**HOMELAND ACRES
FINAL PLAT**
LOCATED IN PORTION OF SECTION 4,
TOWNSHIP 16 SOUTH, RANGE 65 WEST, OF THE 6TH P.M.,
THE CITY OF FOUNTAIN, EL PASO COUNTY COUNTY, STATE OF COLORADO
SHEET 1 OF 2

HOMELAND ACRES

File Number:
SF2416

HOMELAND ACRES

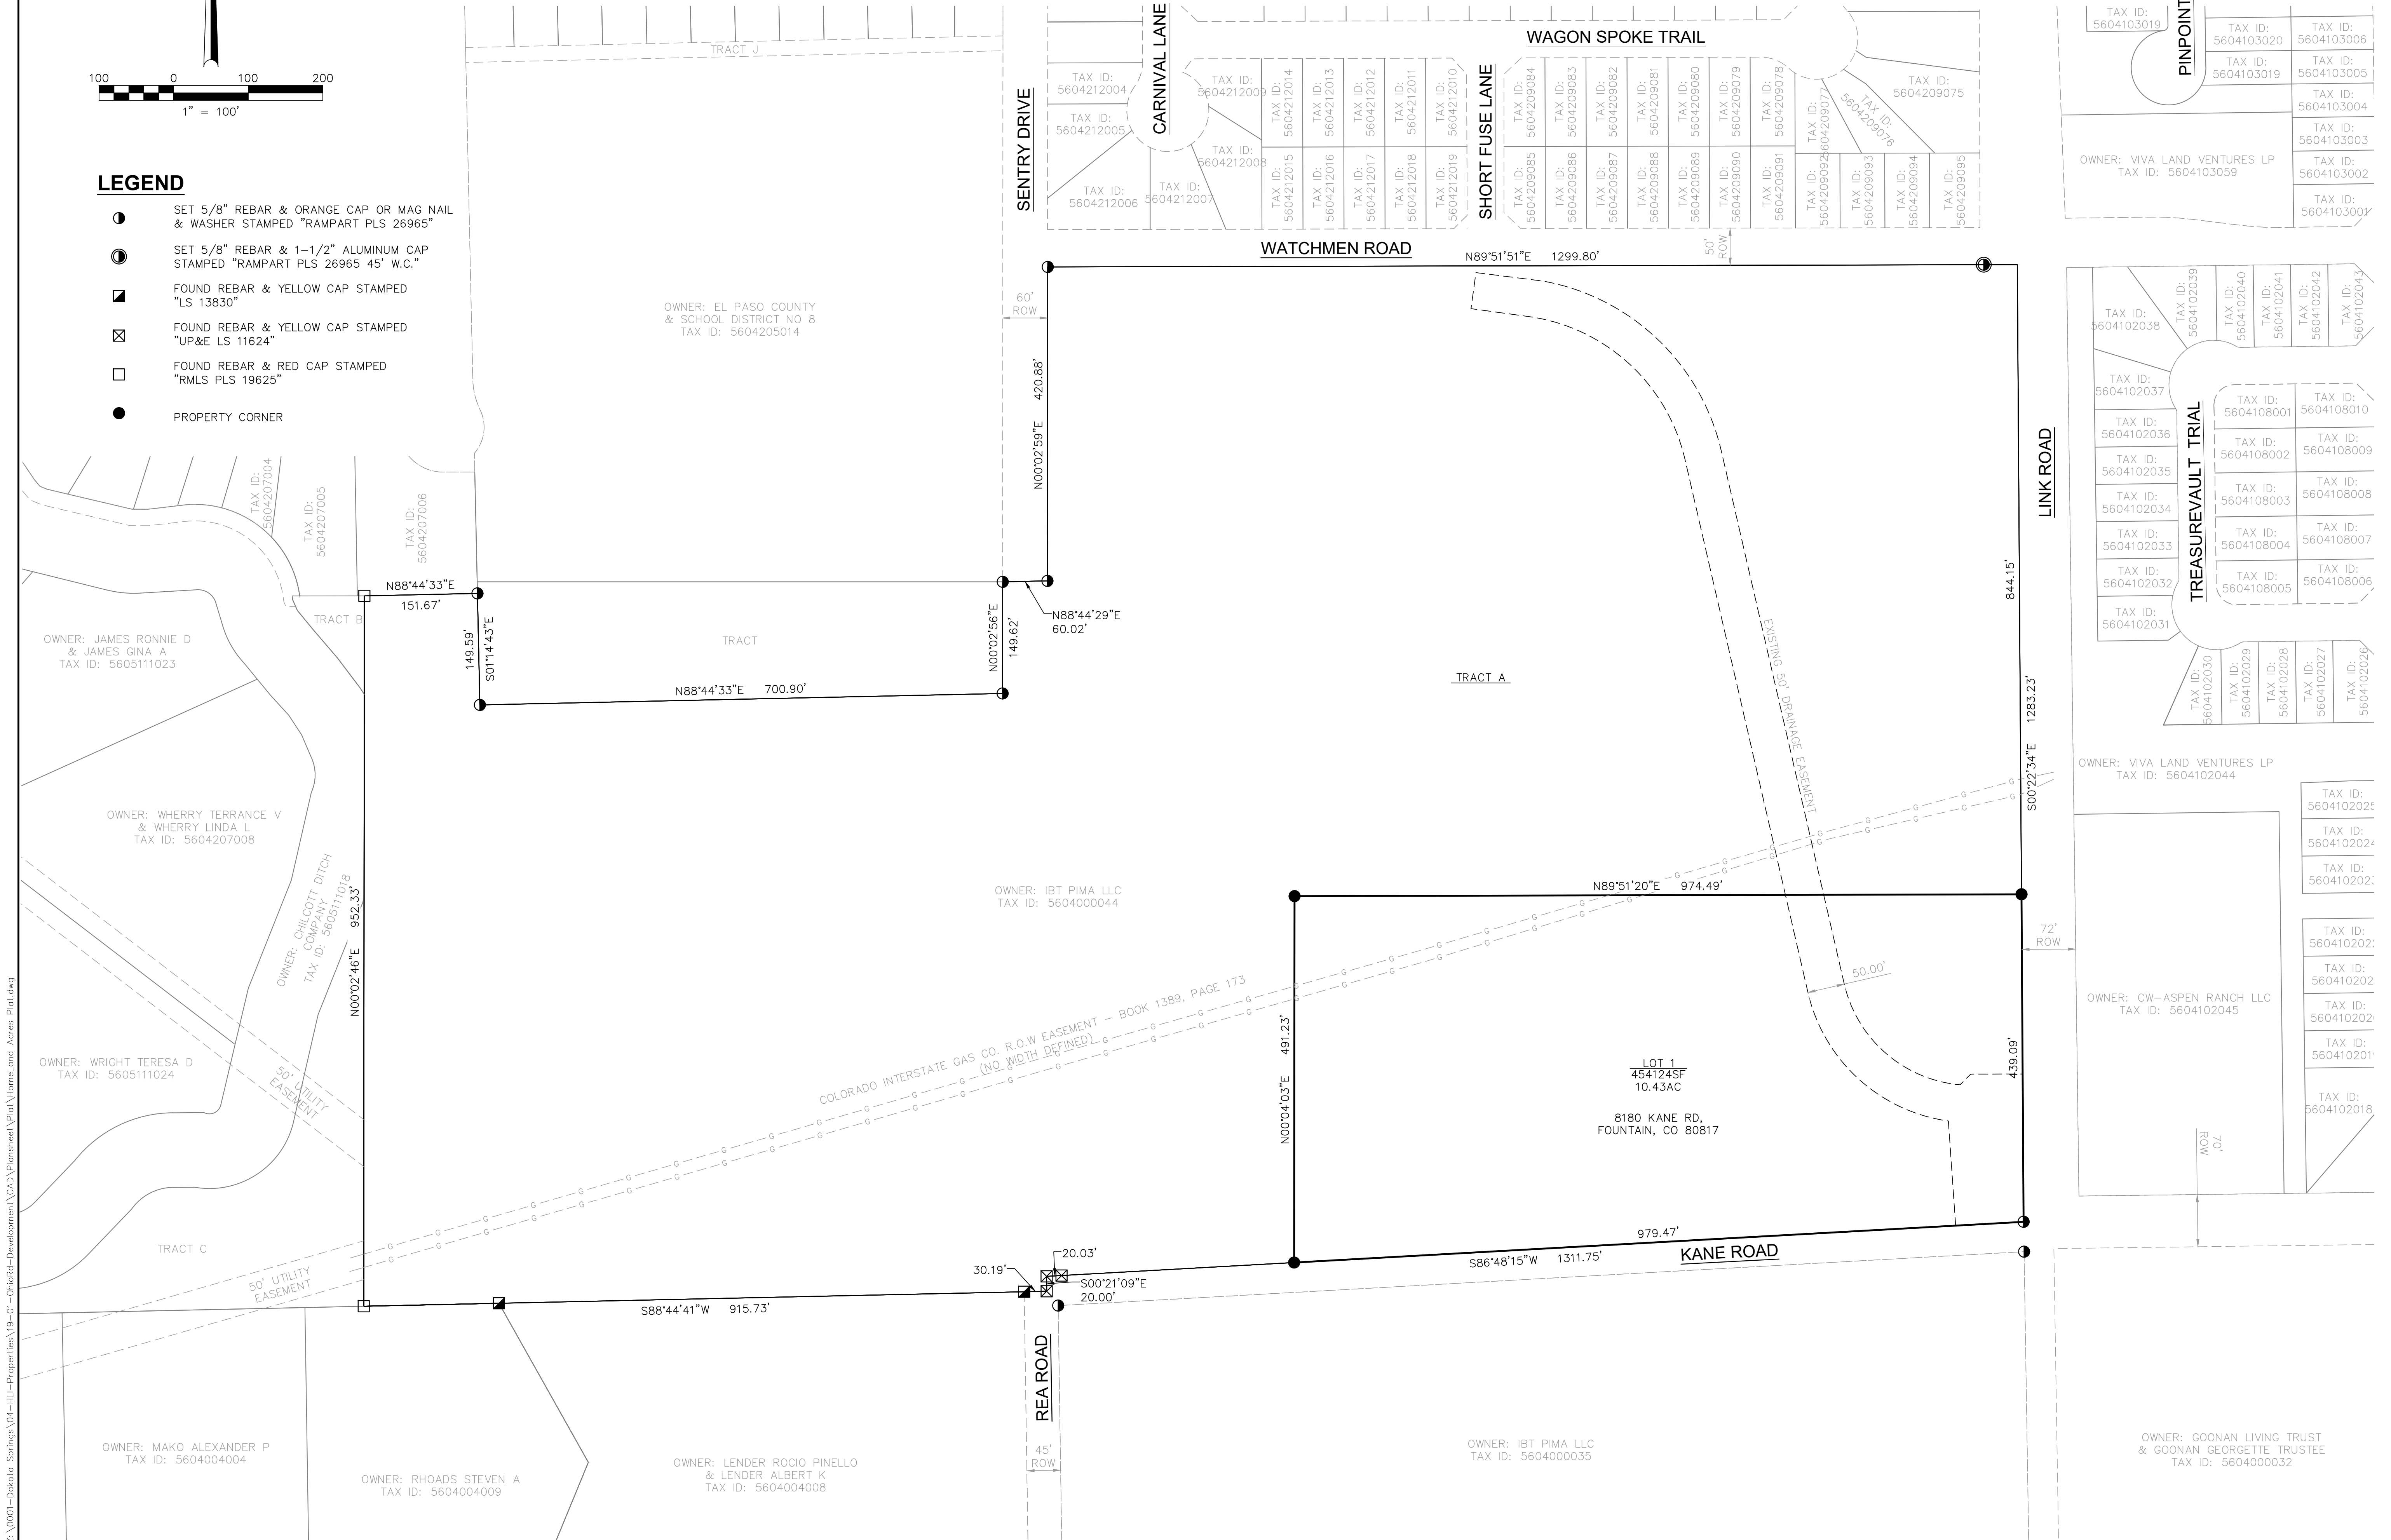
Move this up more by the owner certificate

Please add a line for the director
